TfNSW Reference: SYD24/00712/02

DPHI's Reference: SSD-64916225

**ADVICE ON EIS
WESTERN SYDNEY UNIVERSITY INDIGENOUS CENTRE OF EXCELLENCE
VICTORIA ROAD, RYDALMERE**

TAB A – TfNSW advisory comments

DRAWING TITLE
SITE PLAN - PROPOSED

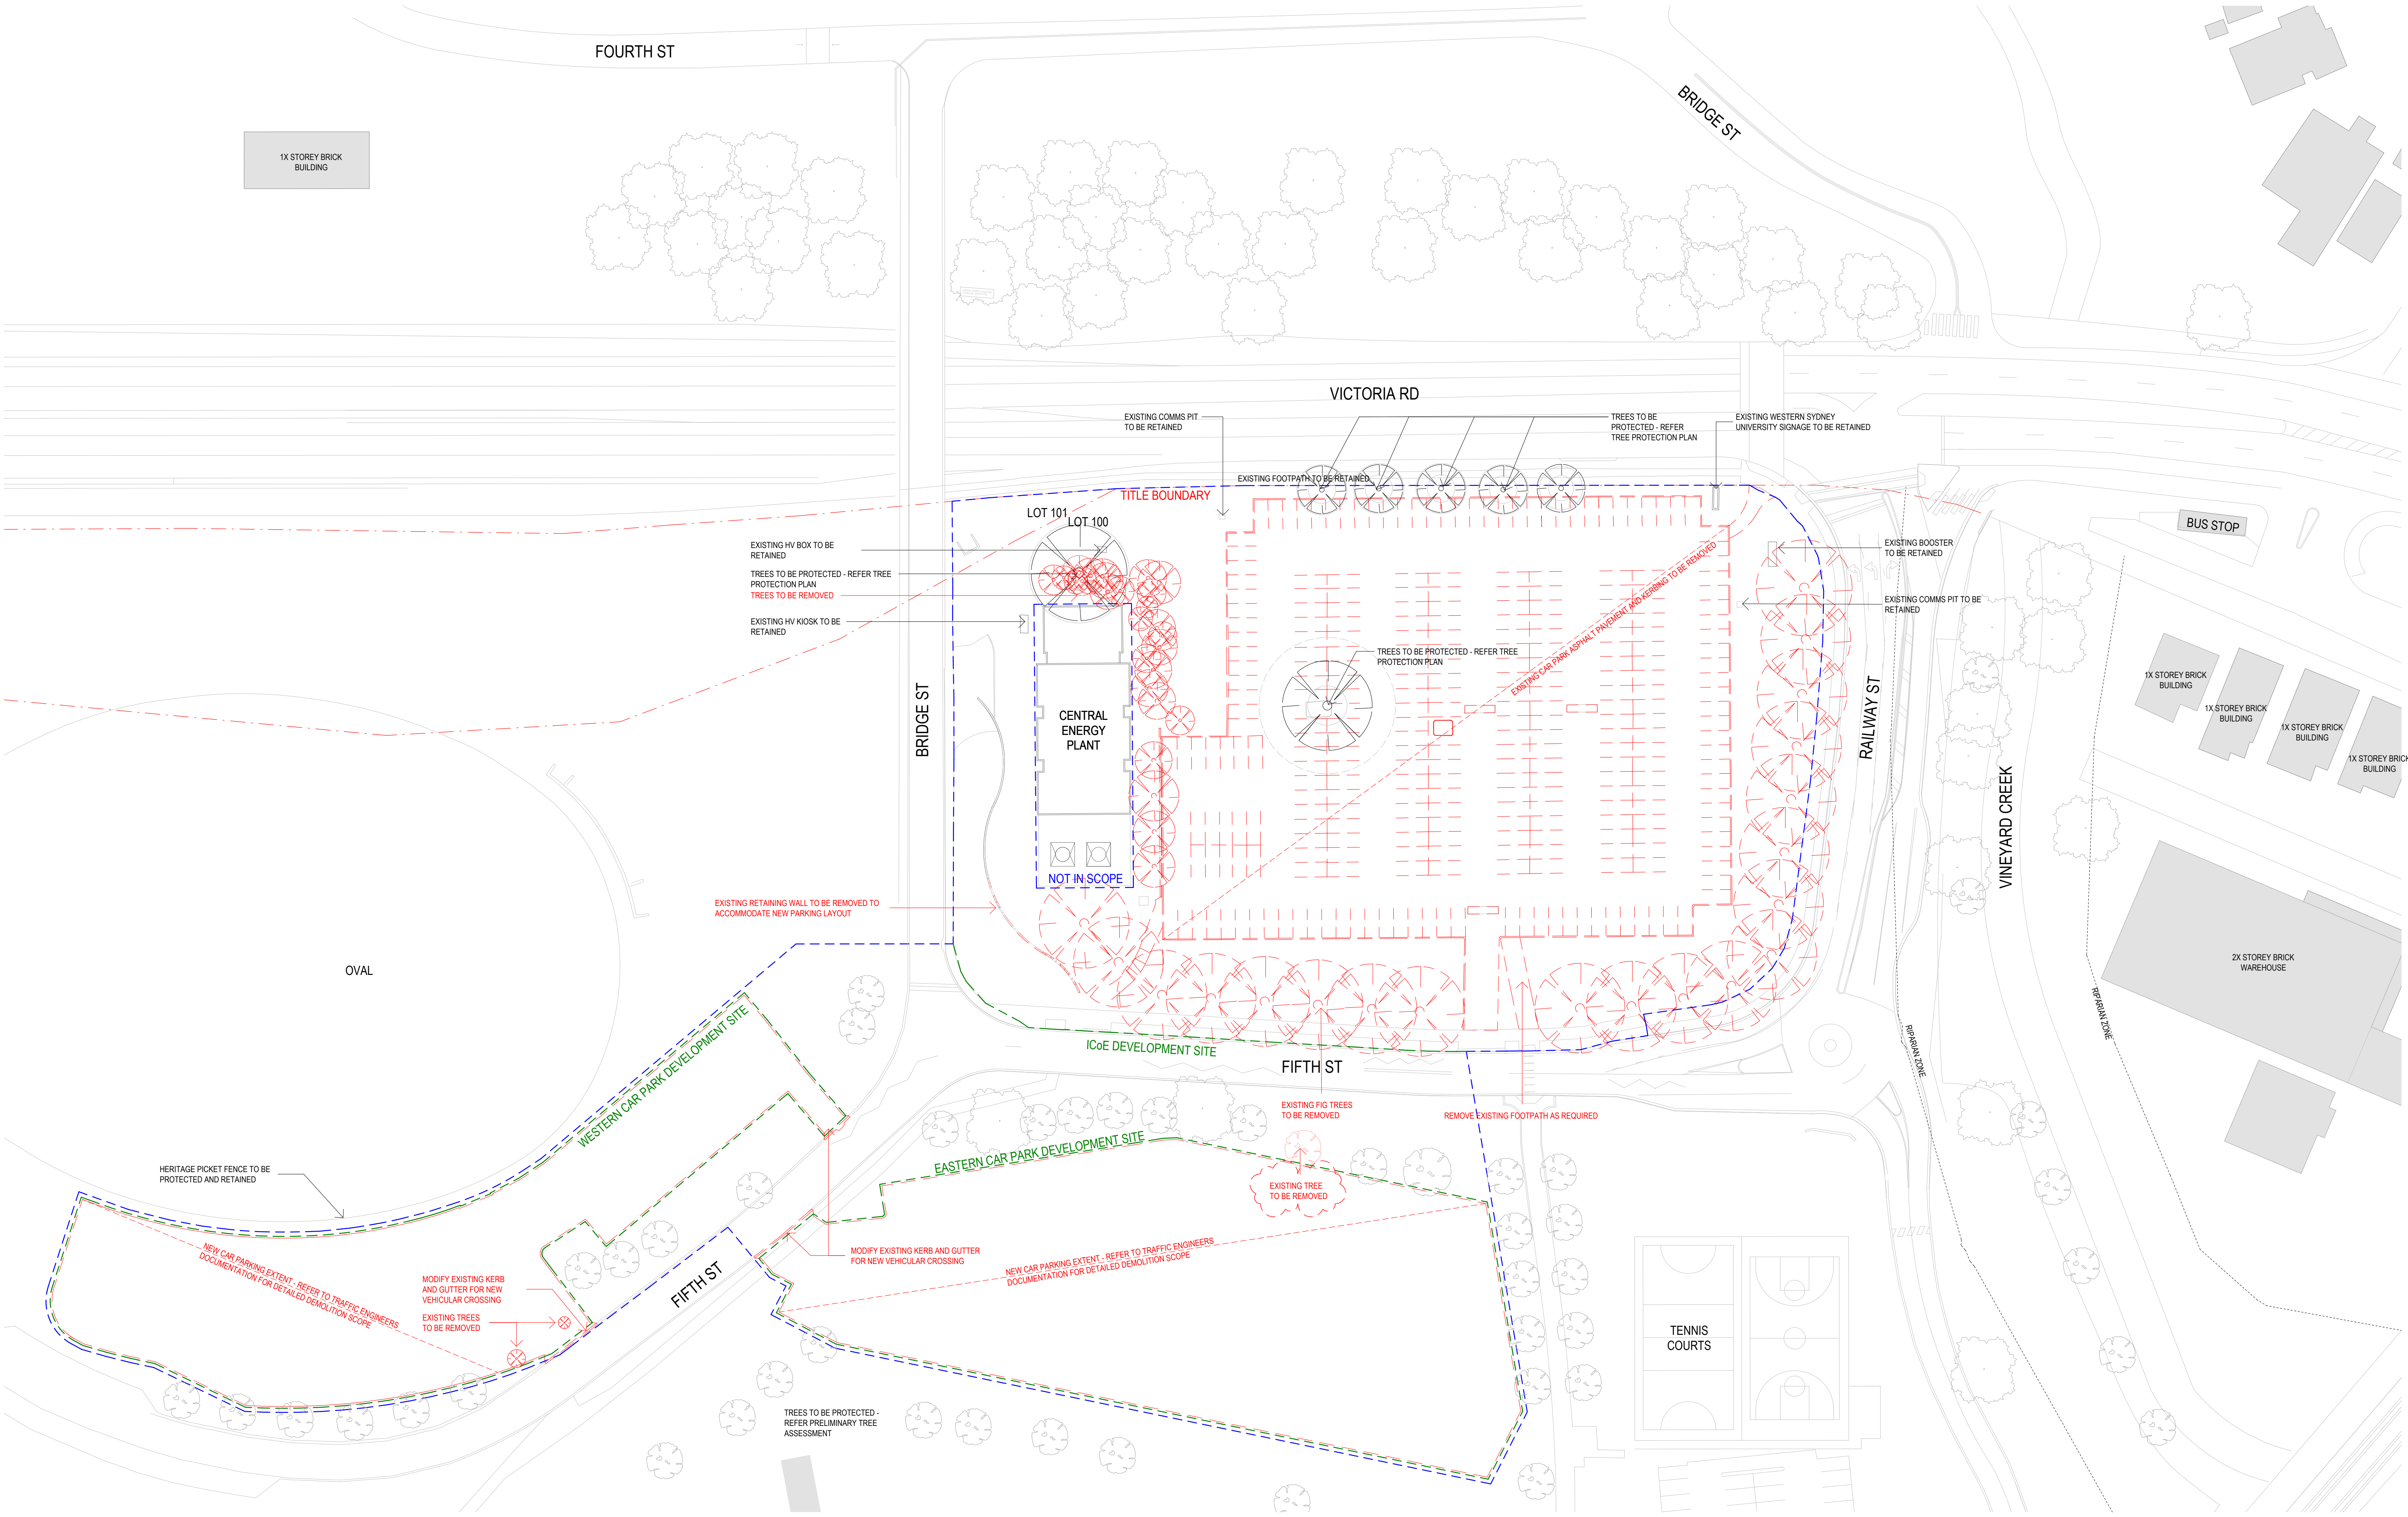
The service road appears that this may cross the property boundary close to the loading bay entry.

The Consent Authority should ensure the development is wholly within the property boundary and does not encroach into the road boundary.
